Our Case Number: ACP-323849-25

Re: The proposed development is for a mixed use development that seeks the regeneration and adaptive reuse of a strategic brownfield site, as part of the Limerick City and County Council 'World Class Waterfront revitalisation and transformation project' 'Cleeves Riverside Quarter' in the townland of Farranshone More in Limerick City.

Planning Ref: 177AE Cleeves Riverside Quarter

Proposed Development: Proposed Mixed Use Development at Cleeves Riverside Quarter, situated on the northern side of the River Shannon, Limerick City, in the townland of Farranshone More.

DRAWING NAME:
Shipyard Landscape plan
DRAWING NUMBER:
1002

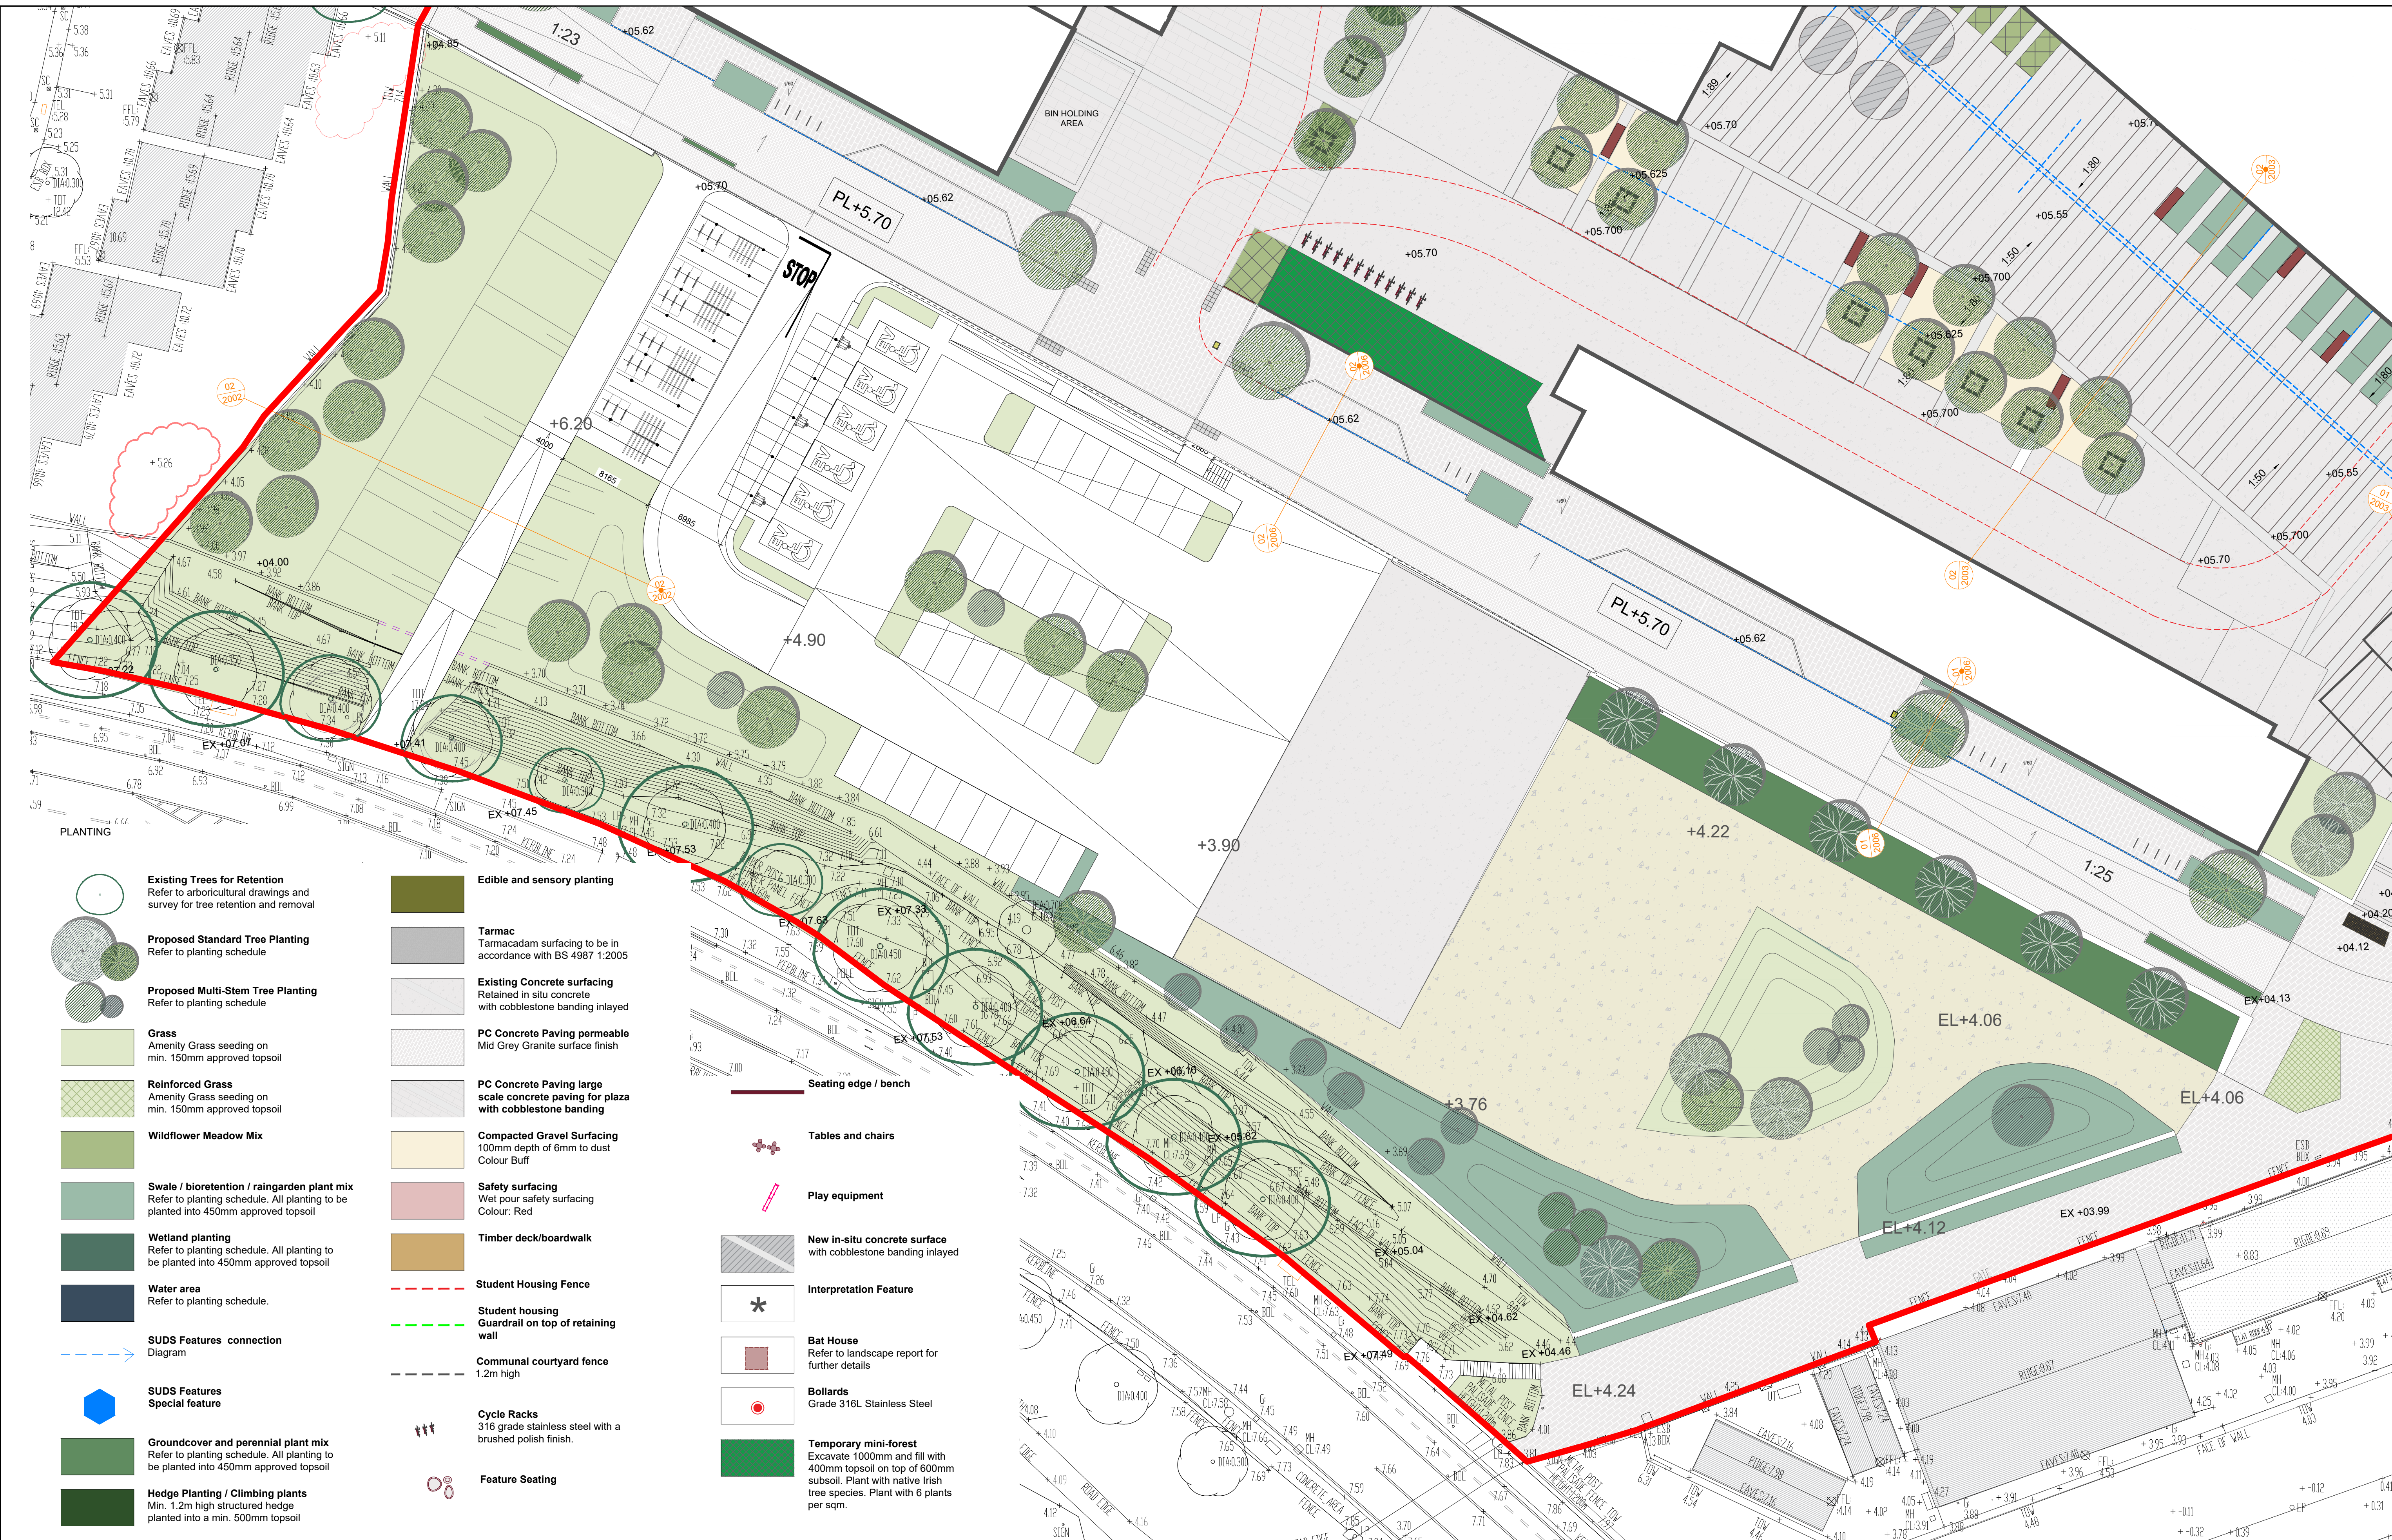
The Department notes that the proposed new ex situ bat house at Clonmacken has the potential to be of significant strategic benefit to Lesser Horseshoe Bats navigating through and around Limerick City, contributing towards landscape connectivity; however, it is crucial that viable commuting corridors from the bat house at the site level are maintained, and that these are also dense enough to provide adequate screening from the nearby greenway lighting.

The landscaping proposals for the Clonmacken site outlined in the supporting information for the Regulation 54 Derogation application (new hedgerow and treeline planting, and reinforcement of existing site boundary hedgerows) are noted. However, the Department has recently become aware that the Office of Public Works proposes to carry out culvert repair works at Clonmacken, involving the construction of a temporary access road along the foot of the embankment to the south of the proposed bat house location, which may necessitate some vegetation clearance along this boundary, reducing screening for the bat house.

It is recommended that any grant of consent would include the following type of conditions:- the implementation of the proposed landscaping plan for Clonmacken in full and simultaneous with construction of the bat house; and the maintenance in an intact condition of all new and existing treelines and hedgerows on site, including any future remedial planting necessary to restore the effectiveness of the treeline at the south of the site.
